TRI-LAKES MONUMENT FIRE PROTECTION DISTRICT

August 22, 2017

El Paso County Development Review
Attention: Kari Parsons
File Number: SP17007

Applicant: Alberts Ranch Preliminary Review

Preliminary Plan for ABERT RANCH SUBDIVISION

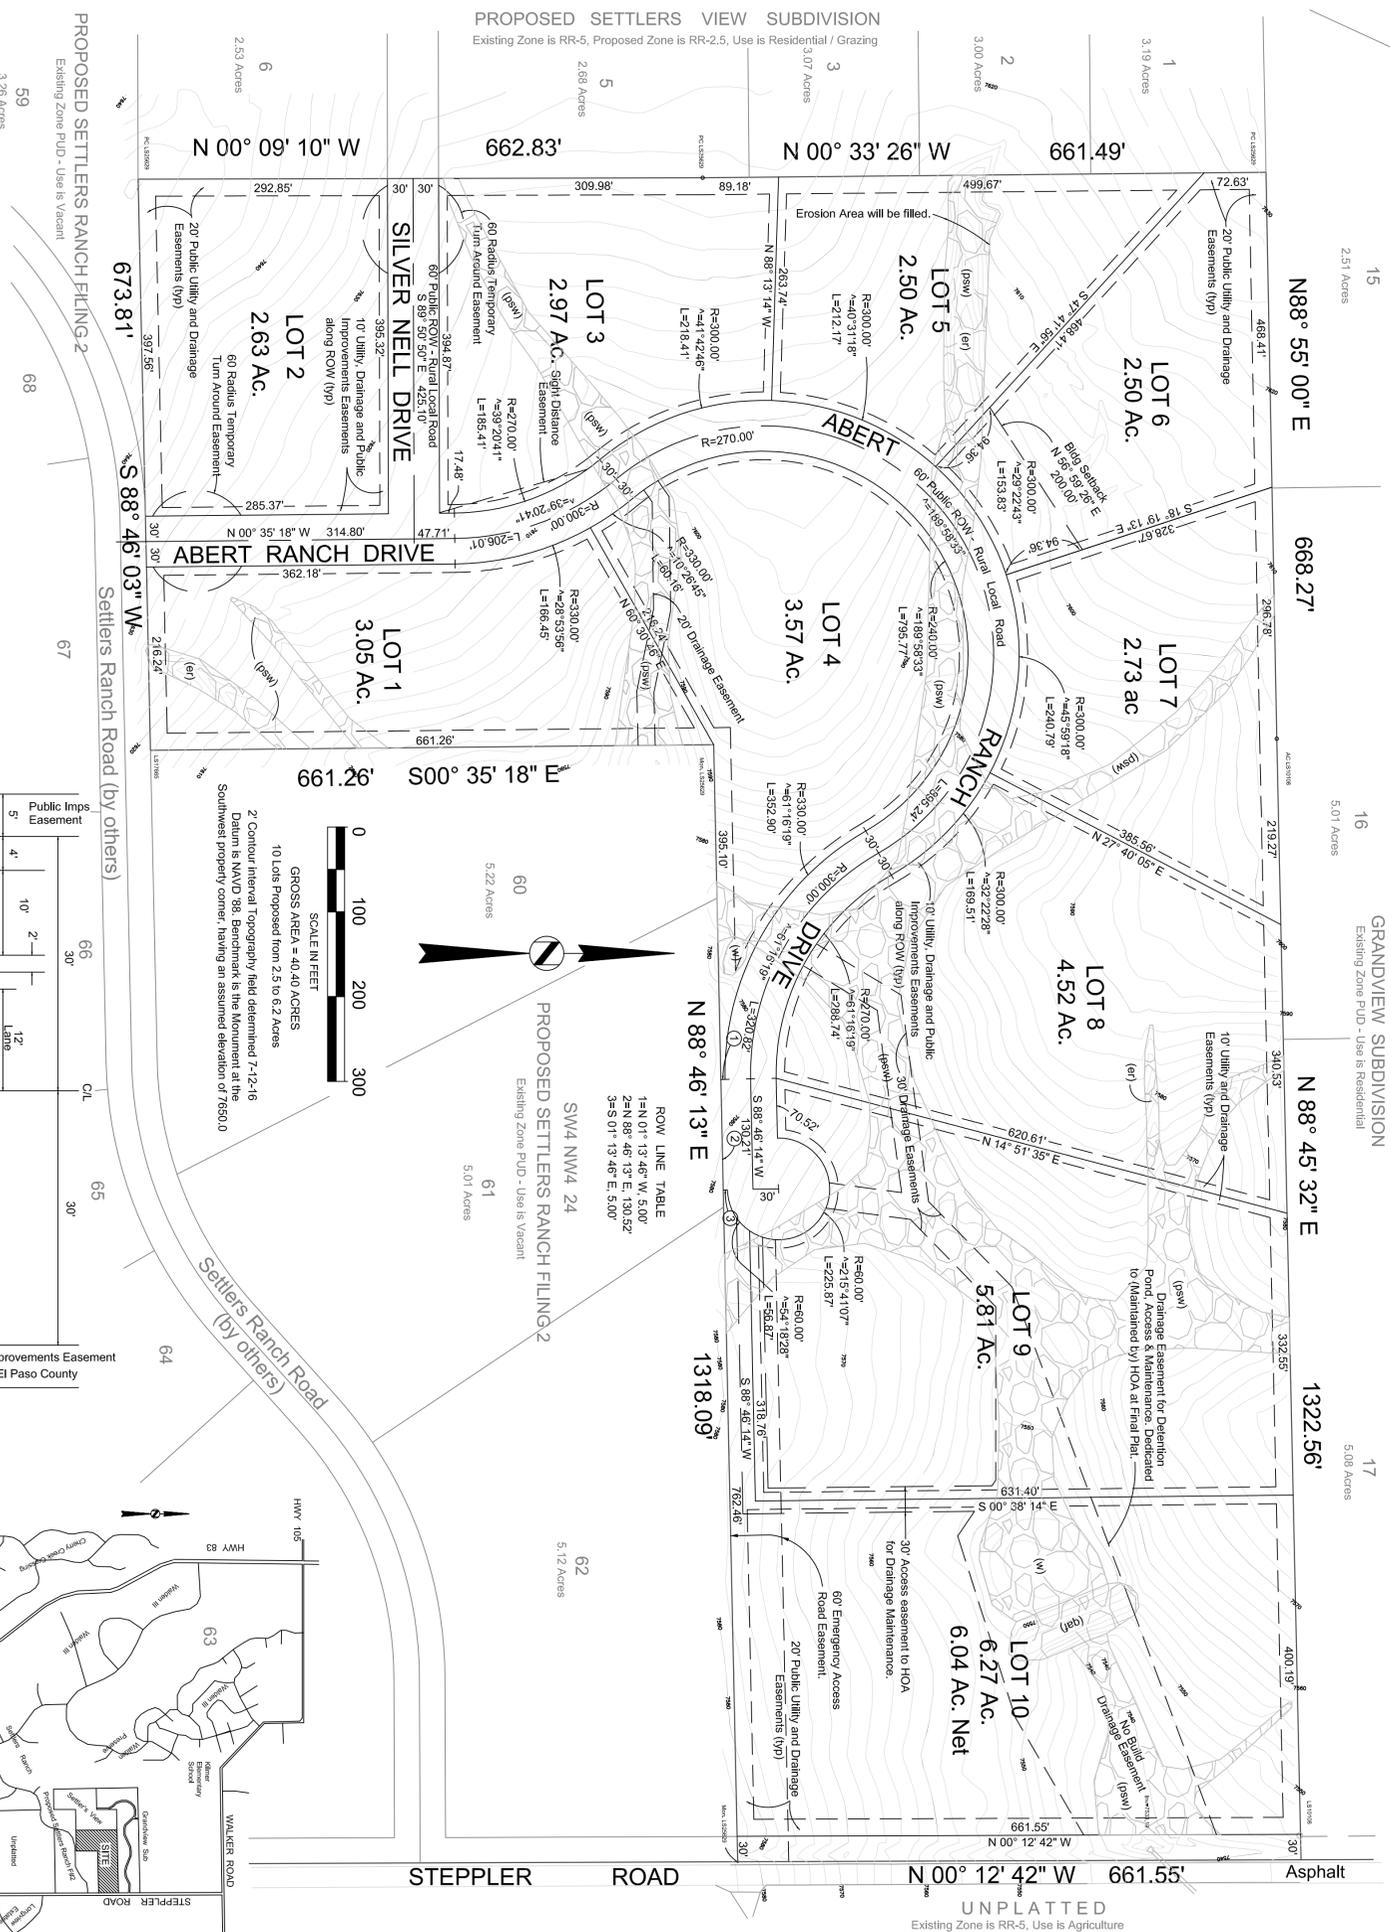
2. Fire hydrant(s) spacing/location per Appendix B. Additional hydrant(s) required.
3. Hazardous Materials: IFC-09/Appendix H has been adopted and shall be completed and submitted with the construction permit drawings as necessary.

8. Coordination with this site and possible development of nearby site(s) should be considered for fire hydrant placement and spacing.
